**TO:** Rick Knowland, Planner  
**FROM:** David Senus, P.E. & Ashley Auger, E.I.T.  
**DATE:** May 24, 2012  
**RE:** Civic Center Renovation, Level III Preliminary Site Plan Application

Woodard & Curran has reviewed the Level III Preliminary Site Plan Application for the Civic Center Renovations located at One Civic Center Square in Portland, Maine. The project consists of building renovations and associated site improvements to the existing Civic Center site.

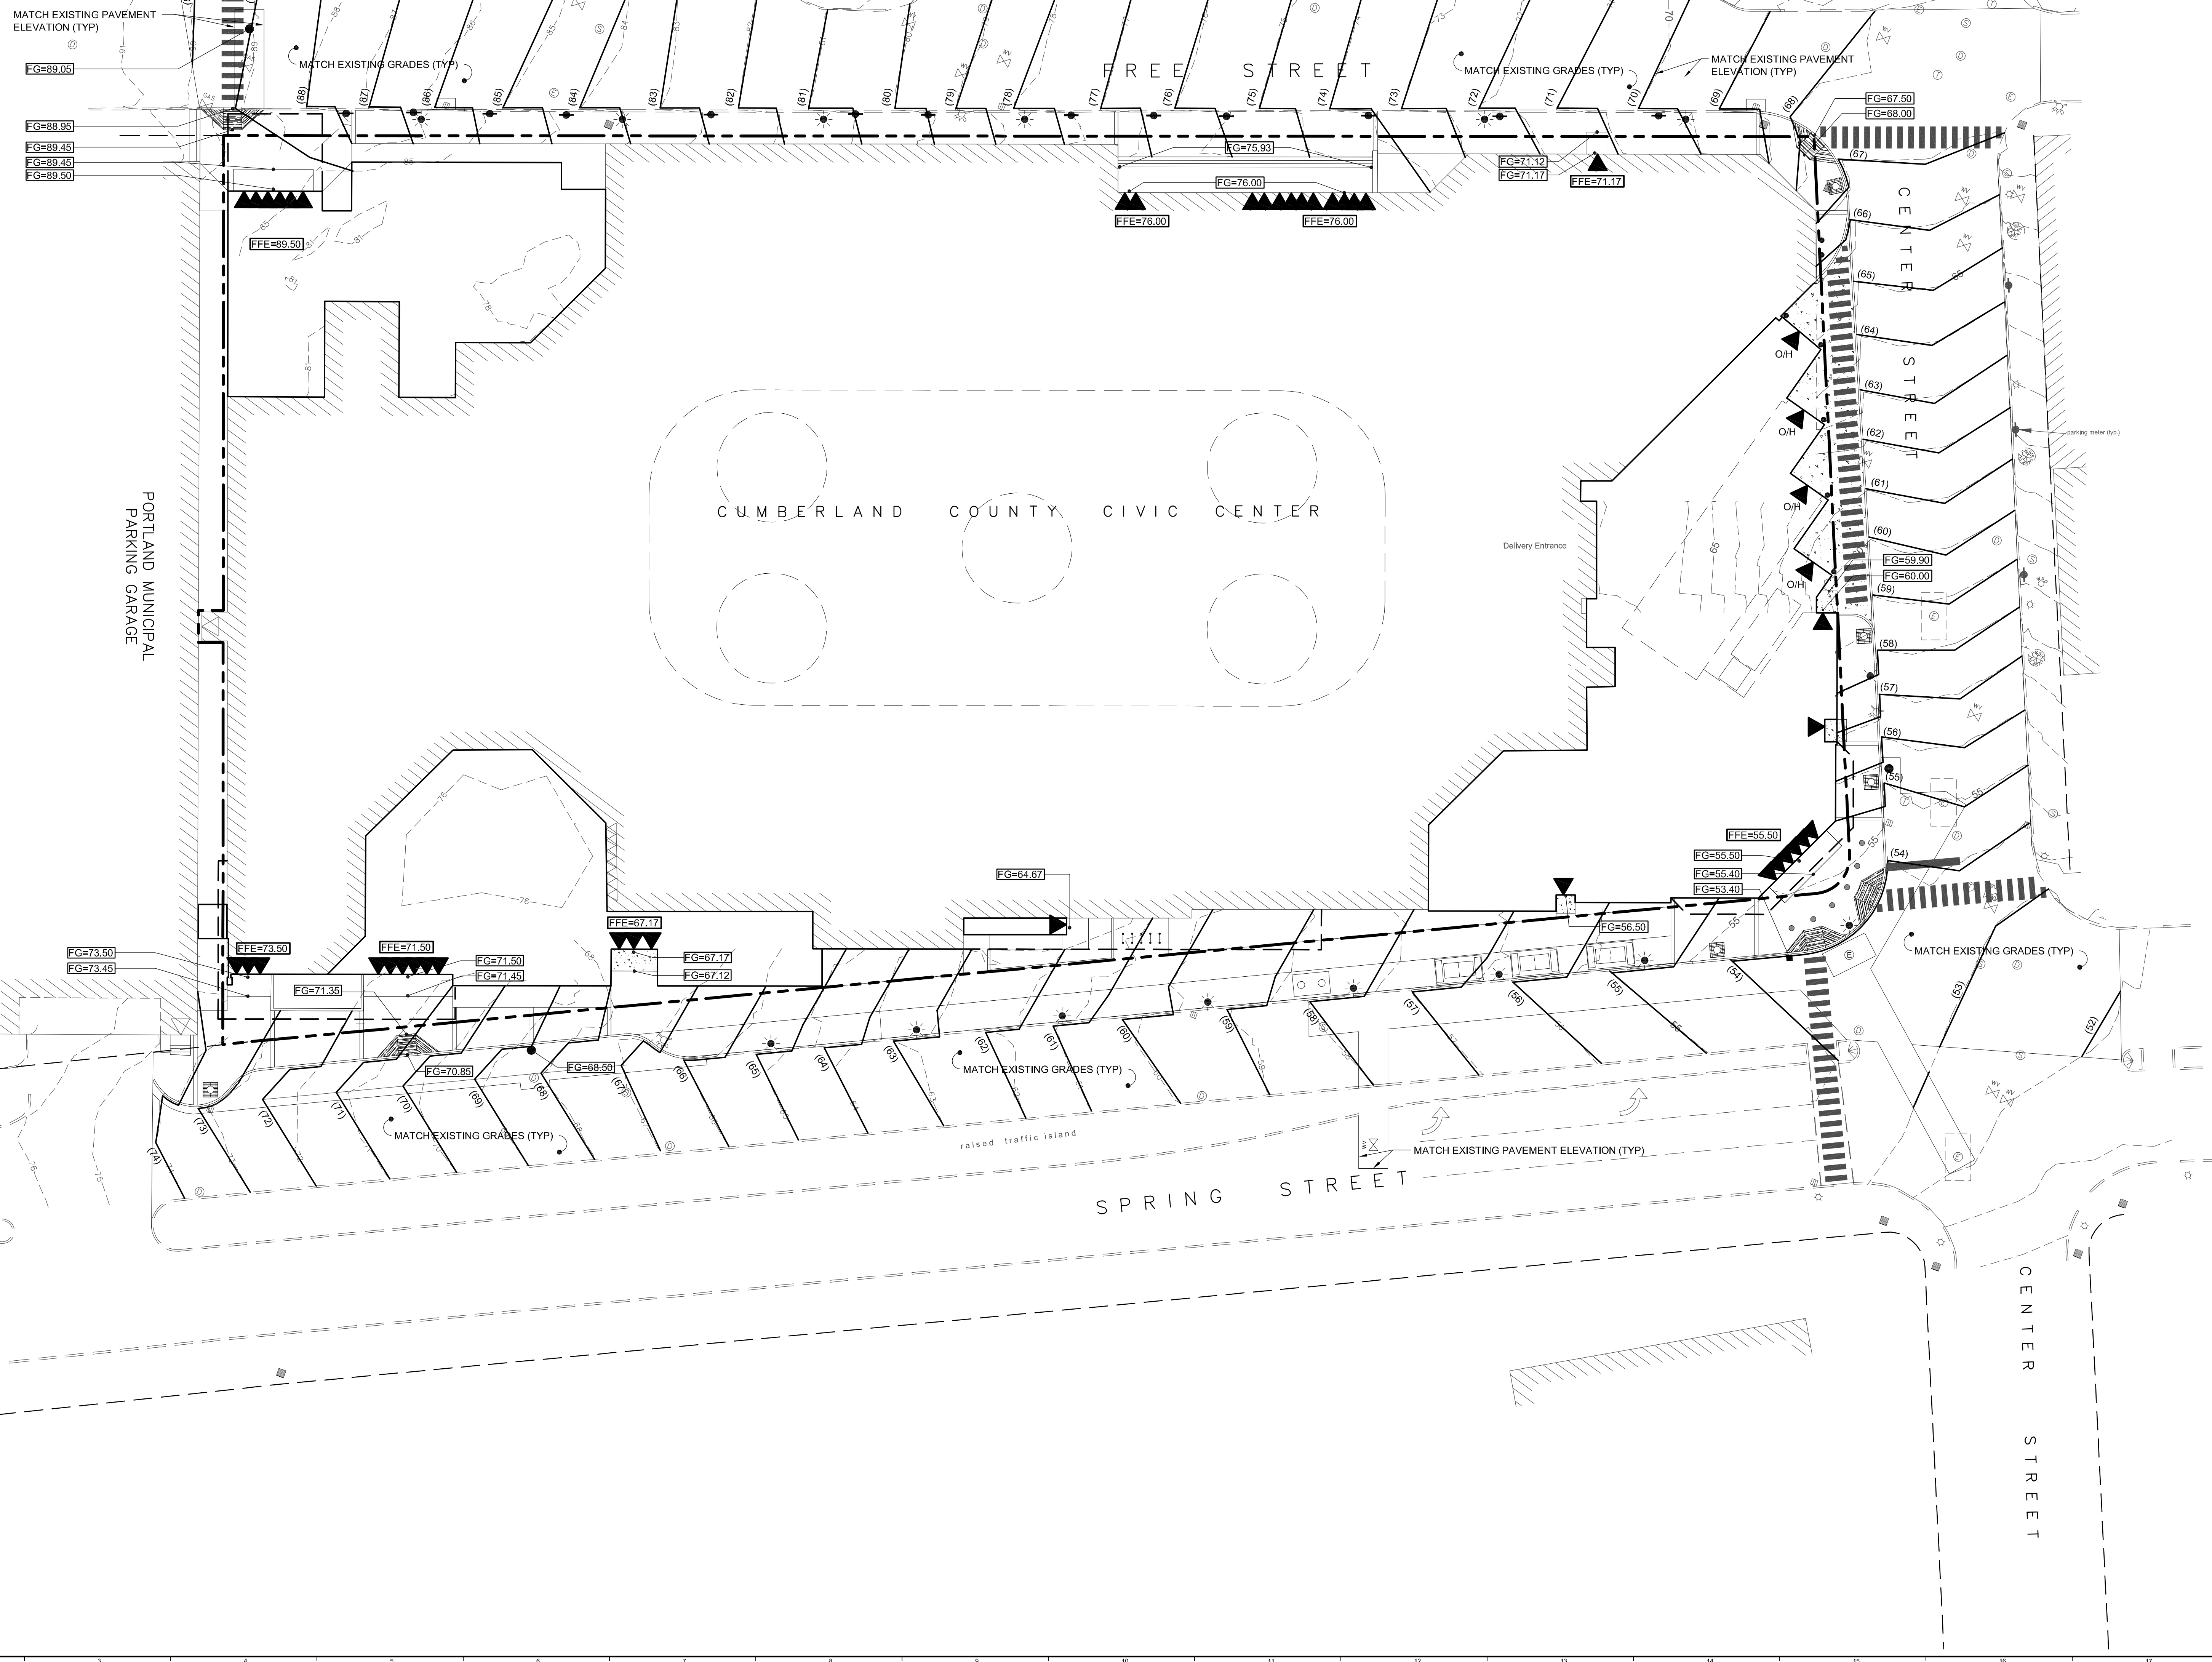
- 2) Final plans must be stamped by a professional engineer (Section 14-527, sub-section (e) of the City of Portland Land Use Ordinance); Sheets PH100 and CG101 have not been stamped at this time.

- b) General Standards: The project proposes an additional 3,572 sq ft of new impervious area. The applicant has not submitted a stormwater management plan addressing the general standards for this increase in impervious area, and the site plan does not include stormwater best management practices in conformance with the general standards.

- c) Flooding Standard: The project proposes to direct stormwater runoff from an additional 3,572 sq ft of new impervious area to the City's storm sewer system. The applicant should provide information on the approximate increase in flow resulting from the project during the design storm events (2, 10 & 25 year, 24-hr) and the discharge location(s) within the City ROW that will receive this additional flow.
